Application No: EP/22/21/HH
Site Address: 15 The Plantation East Preston BN16 1LD
Description of works: Erection of rear extension and loft conversion with rear dormers and side gables

Thank you for your internet representation made on 19th April 2021 which has been recorded as an objection with the comments as follows:

Plans & Elevations As Proposed

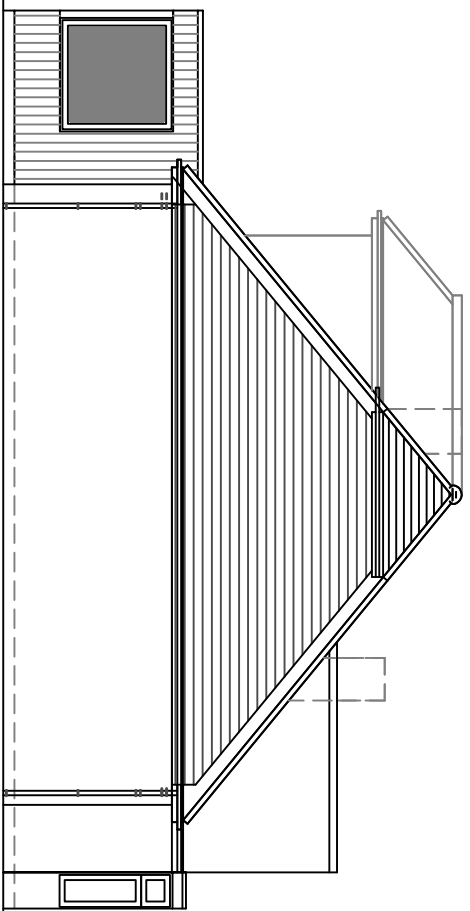
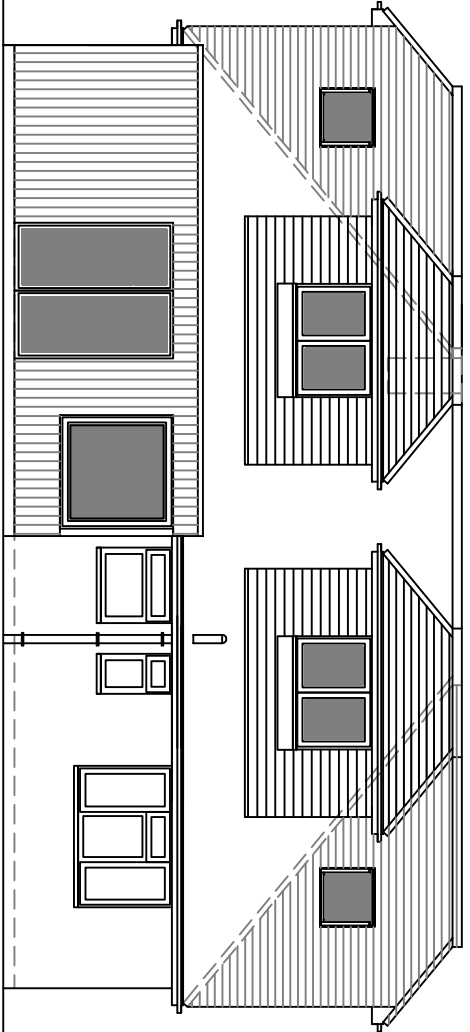
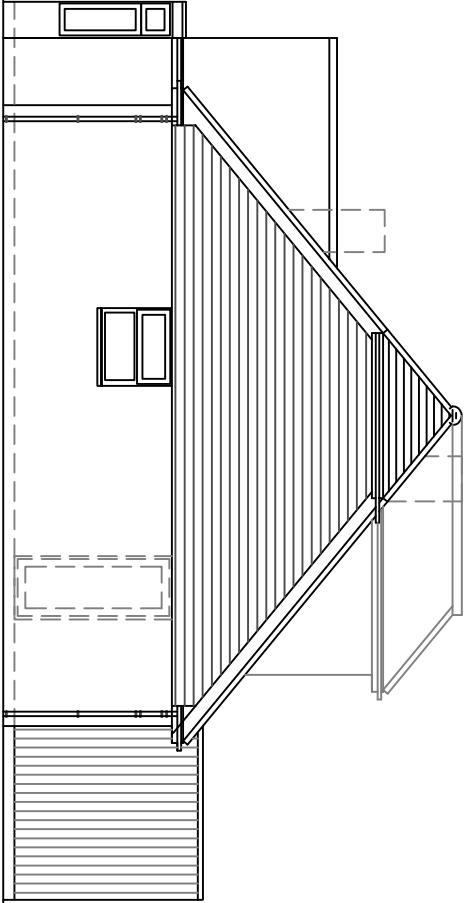
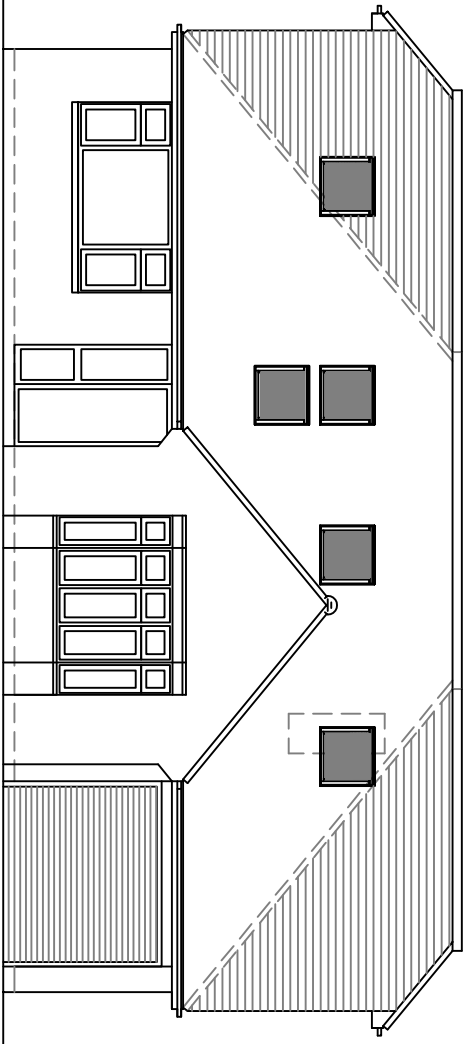
The application proposes a considerably extended roof line with side gables which, if approved, would result in a building which is changed greatly in design, appearance and character. It would not be compatible or in harmony with the neighbouring properties. It would be out of scale and detrimental to the street scene and properties in this quiet road, all of which are 2/3 bedroom 1960s bungalows. There are no houses in The Plantation and none of the detached bungalows have side gables. In addition, the proposal for 5 roof lights on the front elevation seems to be excessive and, again, out of character with neighbouring properties.

The size of the proposed roof will be overbearing and in conflict with the ambience of The Plantation. This application also seems to be contrary to Government Policy which encourages development (which I presume includes any proposals to change the style and appearance of an existing property) which complements and is well integrated with neighbouring properties.

In summary, it appears that the application is for an overdevelopment of a 2 bedroom bungalow to a much larger and overbearing 5 bedroom property with an imposing roof with side gables on both the north and south elevations. It would be hard to describe this as a bungalow. We would therefore request that planning permission is refused.

The proposal to extend the roof line and construct a side gable on the south facing elevation, adjacent to our property, would have a detrimental effect by greatly reducing the natural light available to our bathroom and kitchen windows on the north facing side.

The proposed construction of 2 large dormers on the west facing rear elevation would result in a loss of our privacy as they would enable a direct line of sight to the majority of our rear garden. Also, the application proposes that these dormers would extend from the height of the ridge of the property although the East

Preston Parish Council guidelines are that dormer windows should be "small enough to be subordinate to the appearance of the roof as a whole" and that "the ridge of the dormer should be appreciably lower than that of the main roof". The proposal meets neither of these recommendations.
